### BAKER CONSULTANTS LTD TABLE 1

- (i) the management prescriptions for the Wisley & Ockham Commons component of the Thames Basin Heaths SPA under the Wisley & Ockham Management Plan 2010-2020 (REP10-019, see the 8-page Work Programme table and Figure 3); and
- (ii) HE's proposed compensatory measures in its SPA Enhancement Areas as described in REP4-014 and shown on HE Figure 13 TR010030/APP/5.3 AS-012

Figure 1: Wisley & Ockham Commons Management Plan 2010 – 2020 management prescriptions for woodland clearing / felling shown with the 150m buffer zone from the roads

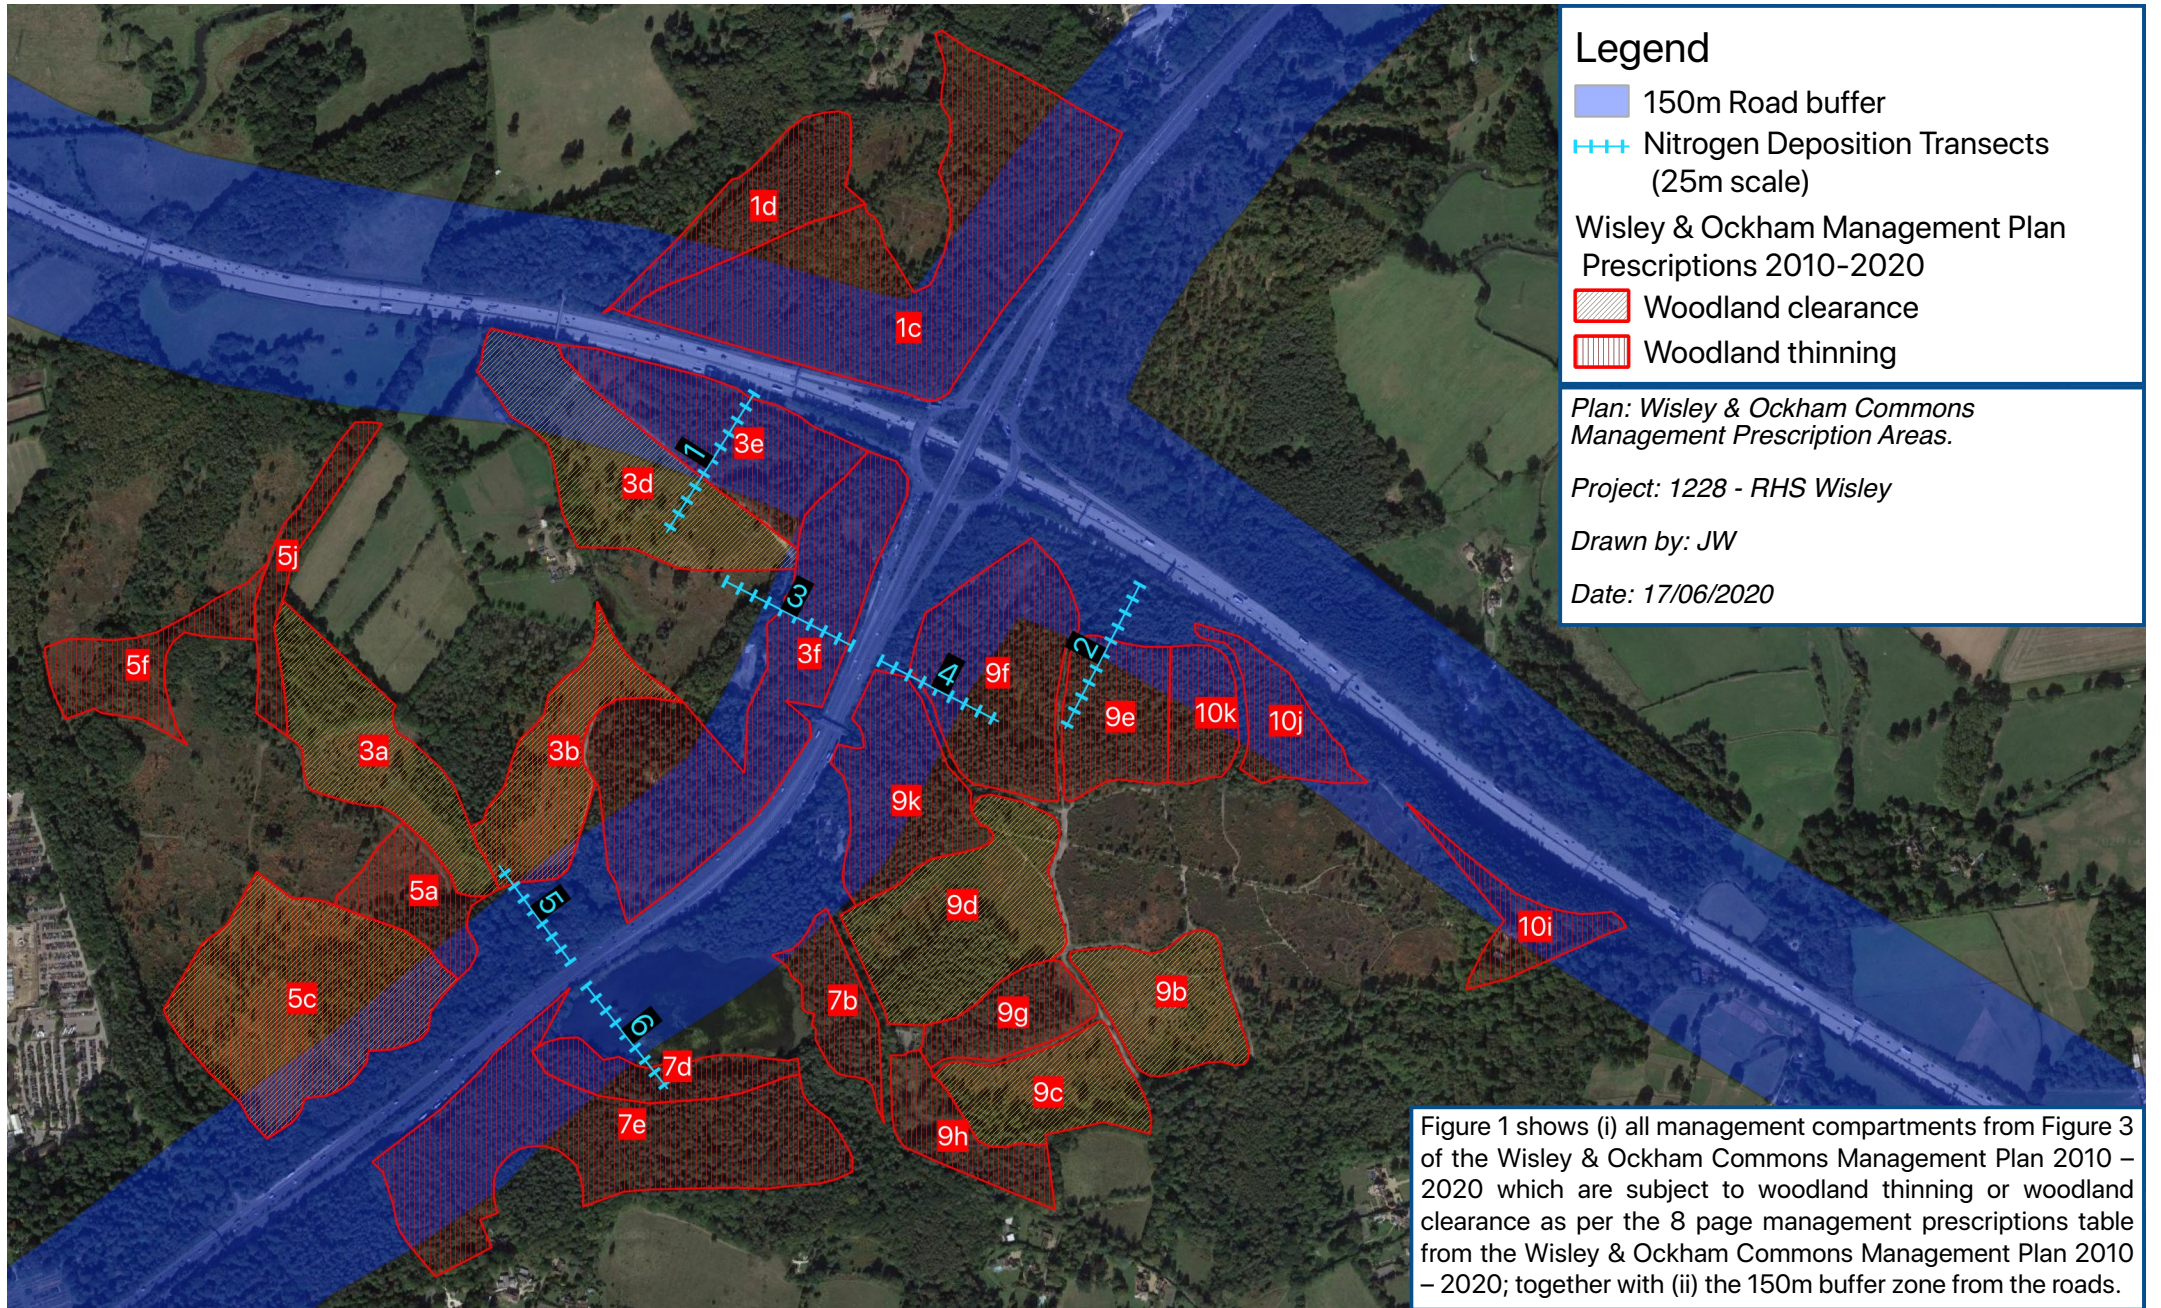
Highways England SPA Enhancement Area	Highways England SPA Enhancement Area compensation measures (REP4-014) (see Baker Consultants Ltd's Figure 2)	Wisley & Ockham Commons Management Plan prescriptions 2010-2020 (REP10-019) (see Baker Consultants Ltd's Figures 1 and 3)	Comparison notes between the management prescriptions for the Wisley & Ockham Commons and HE's proposed compensatory measures in its SPA Enhancement Areas (see Baker Consultants Ltd's Figure 4)
E1 1.9 ha	1.9 ha of Scots pine-dominated mixed woodland proposed for total clearance to allow heathland regeneration (5.1.46-5.1.48 REP4-014 and HE Figure 13 AS-012).	<p>The management plan shows that most of E1 is within compartment 3c<sup>1</sup>. Compartment 3c is under 'scrub control' prescription only (it is not under woodland thinning or clearance) (see MH31 01 at page 1 of 8 of the Wisley Ockham Work Programme 2010-2020).</p> <p>The remainder of E1 is approximately 0.23 ha prescribed by the</p>	<p>HE's proposed compensation amounts to:</p> <p style="color: green;">1.9 ha gain (from scrub control / thinning to clearance)</p>

<sup>1</sup> Management compartments are shown at Figure 3 of the Wisley & Ockham Commons Management Plan 2010-2010 and the (REP10-019). Compartment 3c is not shown on Baker Consultants Ltd's Figures 1 or 3 since 3c's management is not woodland clearance or thinning (it is instead scrub control).

<p>On our calculation, approximately 0.73 hectares of 9d overlaps with the southern area of E2. Compartment 9d is prescribed for tree clearance under the management plan (MH31 02). Therefore the proposed compensation provides no further benefit added to this overlap area.</p>	
E3 4.8 ha	<p>Compensation in this area is split into two areas. The eastern area is designated for woodland clearance for heathland regeneration (3.8 ha), and the western area for woodland thinning (1.0 ha) (5.1.53-5.1.56 REP4-014).</p>	<p>The management plan shows that the eastern area (3.8 ha) of E3 (where compensation is to be clearance) consists of approximately 1.8 ha of compartment 9d and 2 ha of compartment 9g.</p> <p>Compartment 9d of the management plan is already prescribed for clearance (MH31 02) and as such, no further benefit is added to this area. Compartment 9g is to be thinned under the management plan (MH02 01).</p> <p>For the western area of E3 designated for thinning (1.0ha), the management plan prescribes approximately 0.7 hectares for clearance (compartment 9d), and 0.3 hectares for thinning (compartment 9g). Therefore, the</p>	<p>HE's proposed compensation amounts to:</p> <p>2.1 ha no gain (1.8ha from clearance to clearance + 0.3ha from thinning to thinning)</p> <p>0.7 ha downgraded (from clearance to thinning).</p> <p>2ha gain (from thinning to clearance)</p>

Figure 4: Highways England SPA Enhancement Areas E1-E8 (Figure 2) shown with Wisley & Ockham Commons Management Plan 2010 – 2020 management prescriptions (Figure 1), with comparisons of compensation measures between the two.

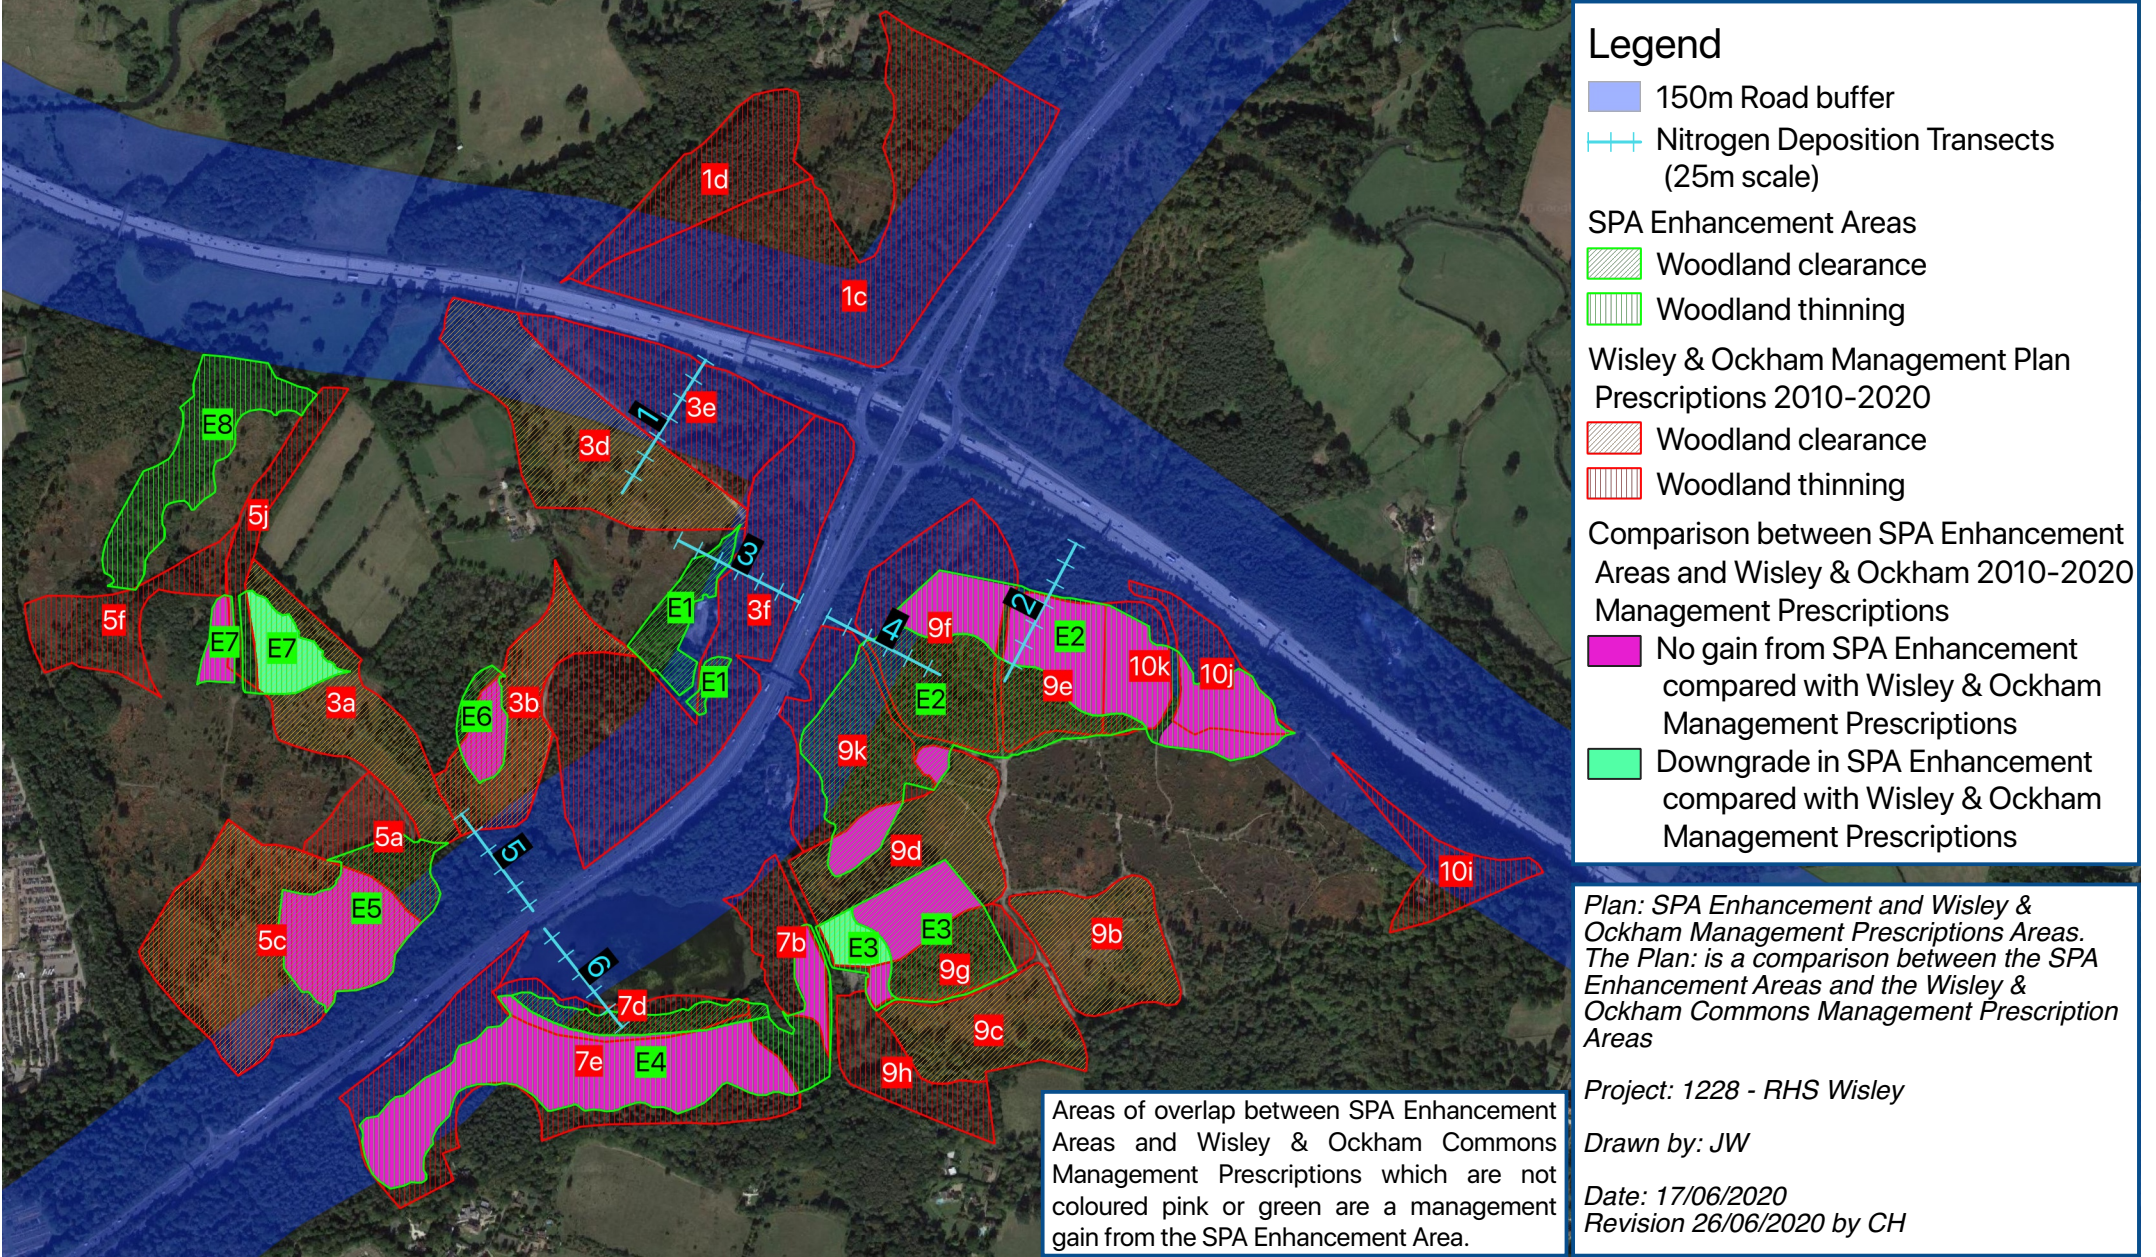
<p>management plan for woodland thinning in compartment 3f.</p>	
<p>E2 17.3 ha</p>	<p>Compensation in this area is split into two areas. The northern area is proposed for woodland thinning (7.9 ha) and the southern area for woodland clearance (9.4 ha) for heathland regeneration including a link to Cockcrow bridge (5.1.49-5.1.52 REP4-014 and HE Figure 13 AS-012).</p>	<p>The northern area (7.9 ha) of E2 corresponds to management compartments 9f, 9e, 10d, 10k, 10j. The management plan has compartments 9f, 9e, 10k and 10j to be thinned (MH02 01). Therefore, the proposed compensation delivers no further benefit. E2 overlaps with 0.79 ha of compartment 10d which the management plan has under the prescription of 'scrub control' (MH31 01) and whilst the proposed compensation is thinning, scrub control and thinning are equivalent in terms of benefits for the SPA birds.</p> <p>The southern area (9.4 ha) of E2 corresponds to management plan compartments 9d, 9e, 9f, 9k and 10k. The management plan shows that areas 9e, 9f, 9k and 10k are to be thinned (MH02 01).</p>	<p>HE's proposed compensation amounts to:</p> <p>8.63 ha no gain (7.9 from thinning to thinning or from scrub control to thinning + 0.73 from clearance to clearance)</p> <p>8.67 ha gain (from thinning to clearance).</p>

proposed compensation shows no gain in most of this area; and a downgrading for the 0.7 ha from clearance to thinning.	
E4 11.3 ha	Compensation in this area is split into two areas. There will be 1.8 ha of woodland clearance adjacent to Bolder Mere and a further 9.5 ha will undergo regeneration thinning. (5.1.57-5.1.59 REP4-014 and HE Figure 13 AS-012).	<p>The management plan shows that E4 covers management plan compartments 7b, 7c, 7d and 7e. The management plan has 7b, 7d and 7e under the prescription of thinning (MH02 01); but not 7c.</p> <p>The area of E4 designated for thinning, covered by management compartments 7b, 7d and 7e therefore provides no additional gain. Compartment 7c is not under any prescription in the management plan for either felling or thinning.</p>	<p>HE's proposed compensation amounts to:</p> <p>8.54 ha no gain (from thinning to thinning)</p> <p>2.76 ha gain (from thinning to clearance)</p>

E5 4.5 ha	Compensation in this area of 4.5 ha is total woodland clearance of the Scots pine-dominated woodland (5.1.60-5.1.61 REP4-014 and HE Figure 13 AS-012).	The management plan shows that area E5 comprises of approximately 1.07 ha of compartment 5a and approximately 3.43 ha of compartment 5c.	<p>HE's proposed compensation amounts to:</p> <p>1.07 ha gain (from thinning to clearance)</p>

<p>The 1.07 ha of compartment 5a is prescribed for thinning under the management plan (MH02 01).</p> <p>The proposed compensation will provide no gain for the remaining 3.43 ha of E5 comprising of compartment 5c, which is already prescribed for a both thinning and for clearance under the management plan (MH02 01, MH31 02).</p>	<p>3.43 ha no gain (from thinning / clearance to clearance)</p>
E6 1.2 ha	<p>Compensation in this area of 1.2ha is total woodland clearance (5.1.62-5.1.63 REP4-014 and HE Figure 13 AS-012).</p>	<p>The area at E6 overlaps mainly with management plan compartment 3b. The management plan prescribes both thinning and clearance for this compartment 3b (MH02 01, MH31 02). Therefore the proposed compensation provides no gain.</p> <p>A small part of E6 (0.31ha) is also covered by management plan compartment 3g and the management plan here provides for no thinning or clearance in this 3g area.</p>	<p>HE's proposed compensation amounts to:</p> <p>0.89 ha no gain</p> <p>0.31 ha of gain.</p>

E7 2.4 ha	<p>E7 comprises two areas totalling 2.4ha. According to our calculations the smaller area to the west is 0.64 ha and there is larger area to the east of 1.76ha. Compensation in this area is woodland</p>	<p>E7 comprises of management compartments 5j, 3a and 6. For these compartments the management plan prescribes approximately 0.38ha of this</p>	<p>Comparison of the prescriptions therefore show:</p> <p>0.95 ha no gain (from thinning to thinning or scrub control to thinning).</p>

thinning (5.1.64-5.1.66 REP4-014 and HE Figure 13 AS-012).	<p>area for thinning (MH02 01), and 1.45ha for clearance (MH31 02).</p> <p>The proposed compensation at E7 therefore adds no additional value to the 0.38 ha area and provides a downgrading for the remaining 1.45 ha.</p> <p>The eastern part of E7 overlaps with compartment 6 which is under prescription MH31 01 scrub control and therefore the proposed thinning has no additional benefit.</p>	1.45 ha downgraded (from clearance to thinning).
E8 4.2 ha	Compensation for this area of 4.2ha is woodland thinning (5.1.67-5.1.69 REP4-014 and HE Figure 13 AS-012).	This area has no previous prescriptions under the management plan for woodland thinning or clearance.	Comparison of the prescriptions therefore show: 4.2 ha gain.

The above Table 1 shows that, of the total of 47.6 ha of SPA Enhancement areas, 23.96 ha amounts to no gain and 2.15 ha amounts to a downgrade compared with the Wisley and Ockham Commons Management Plan 2010-2020.
